Ref: OA2025/0005

Subject:	Request for Response to SSD-69223466
Application No:	OA2025/0005
Property:	132 McCredie Road, Guildford West NSW 2161
Proposal:	Construction of 2 storeys data centre comprising 9 data halls with ancillary office, at-grade car parking, signages and associated landscape and site works in 2 stages (Project Pluto Data Centre)

Council has reviewed the submitted information and the following response is provided.

Landscape Concept

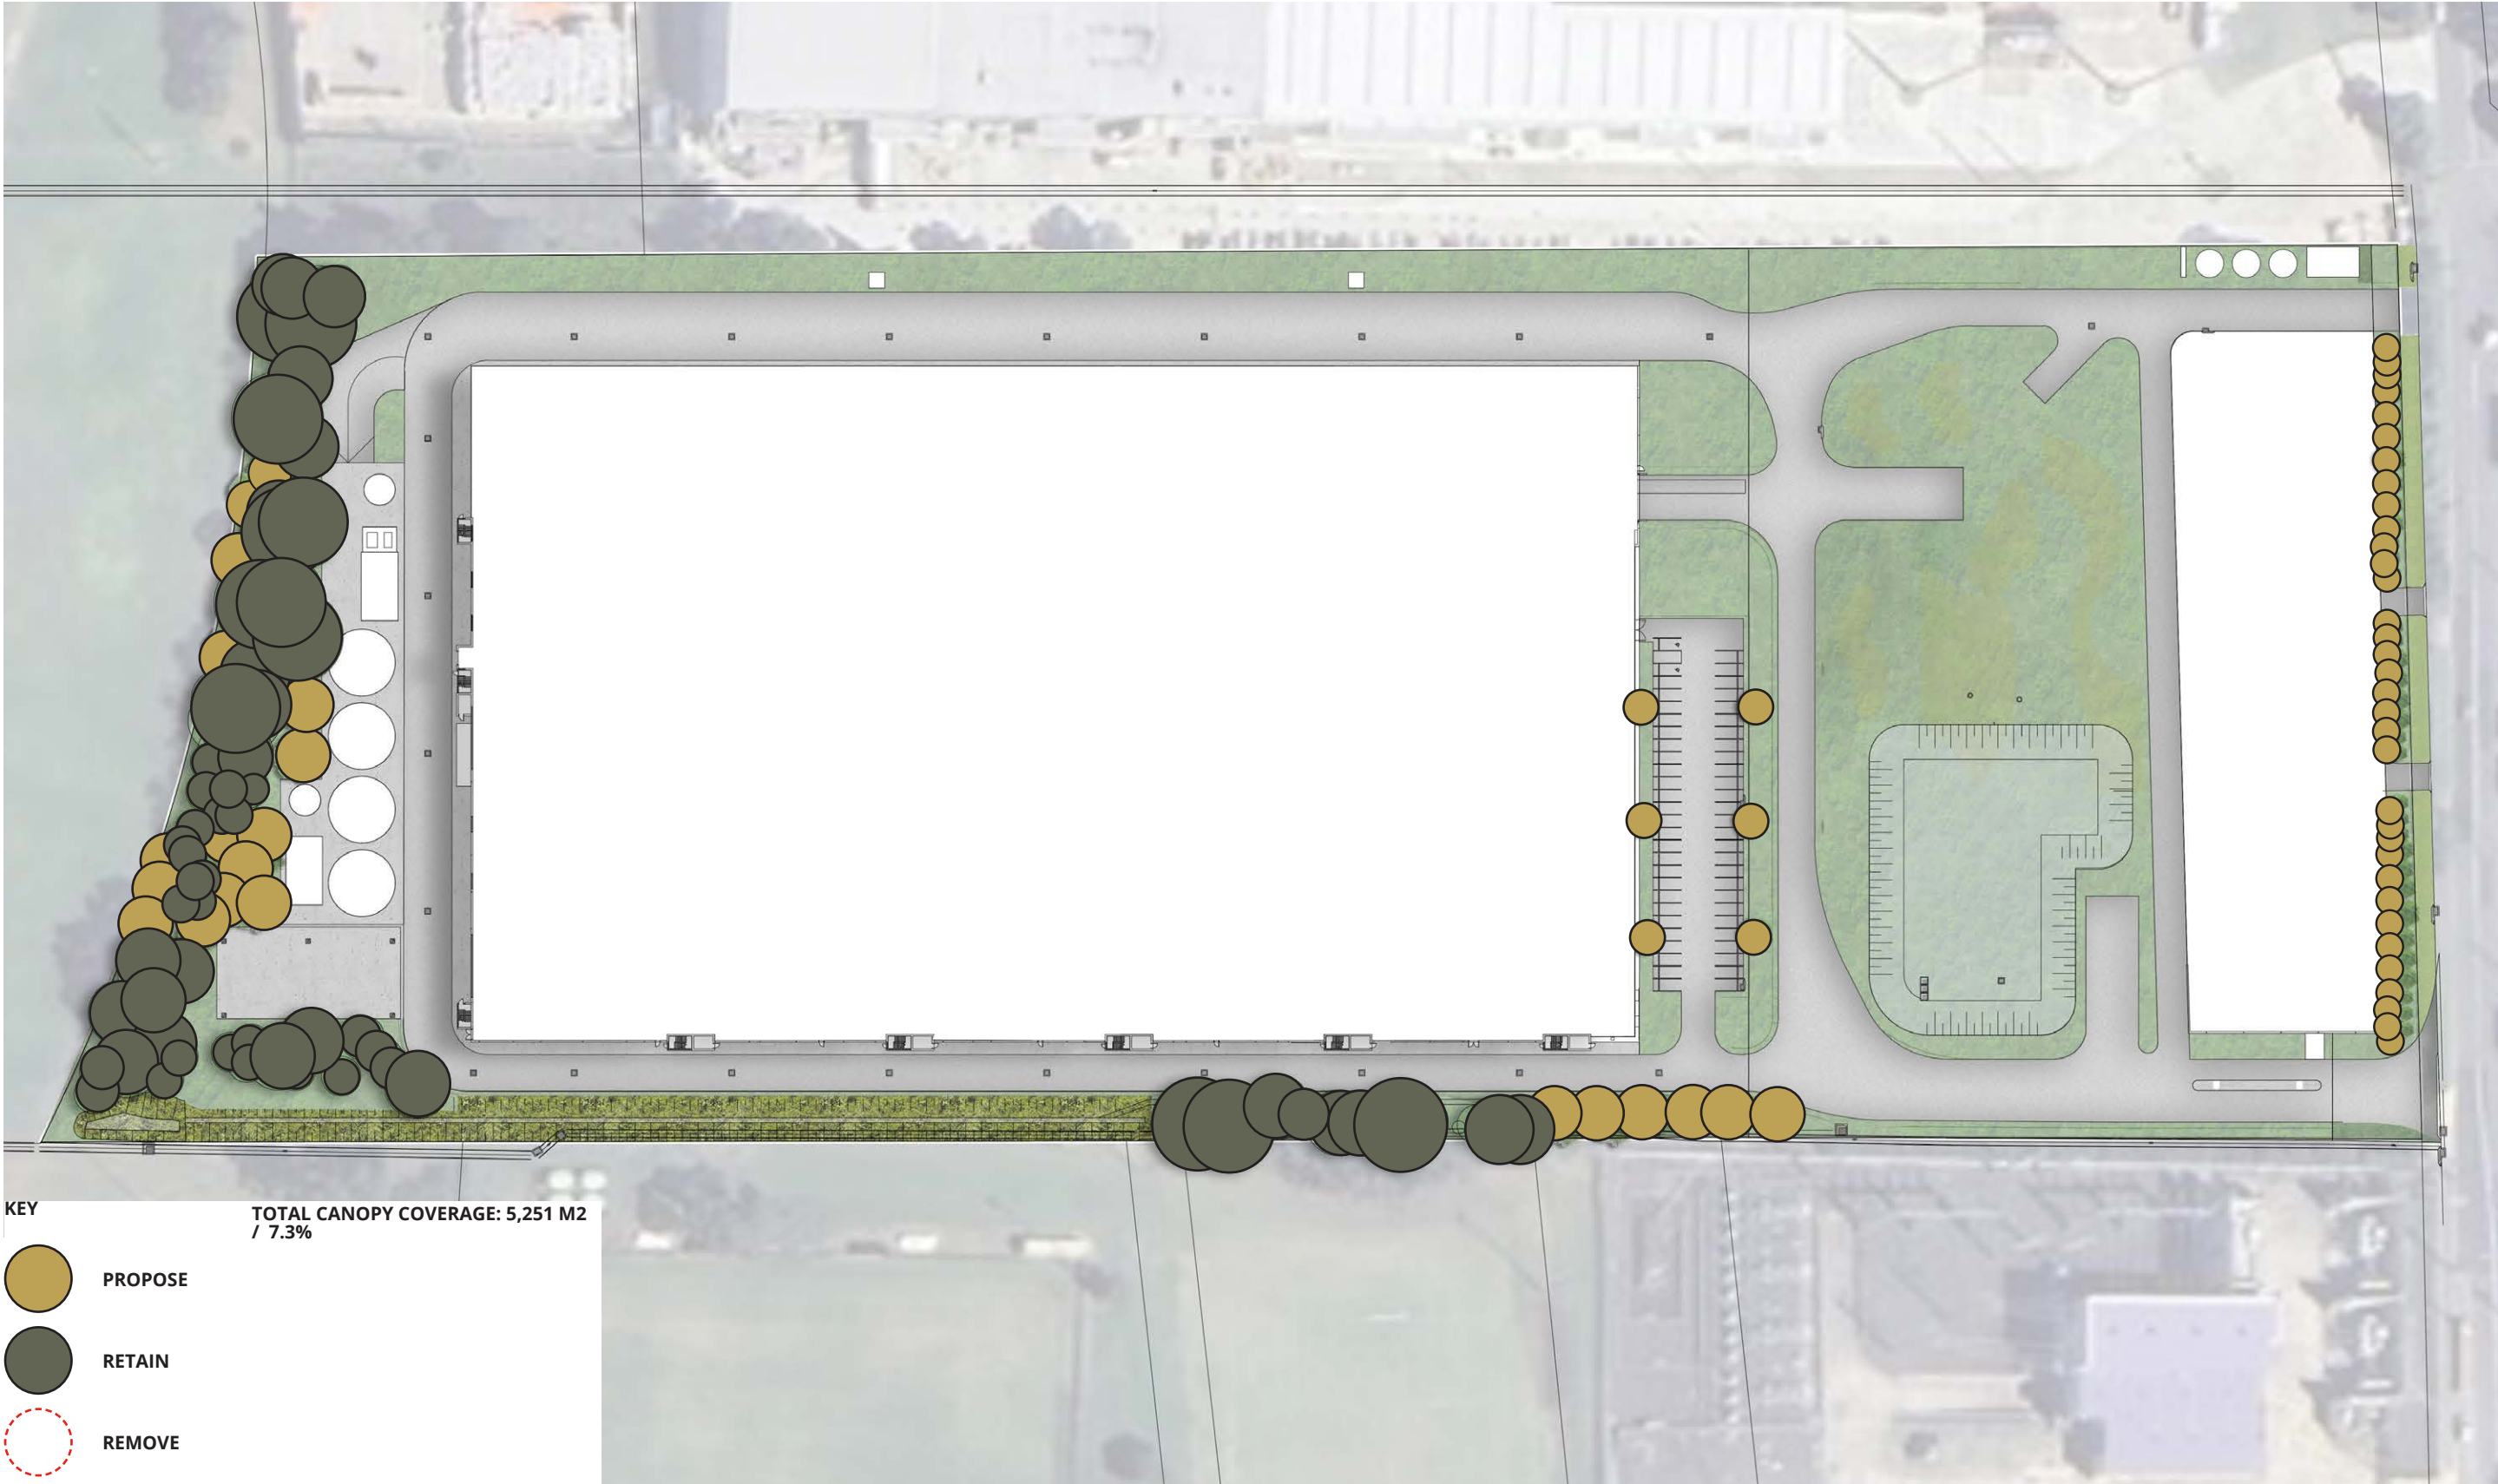
The proposal has been designed to provide a large car parking area located forward of the proposed data centre building. Accordingly, landscaping shall be planted in the rate of 1

shade tree for 10 spaces shall be planted within the large open car parking area for new industrial development.
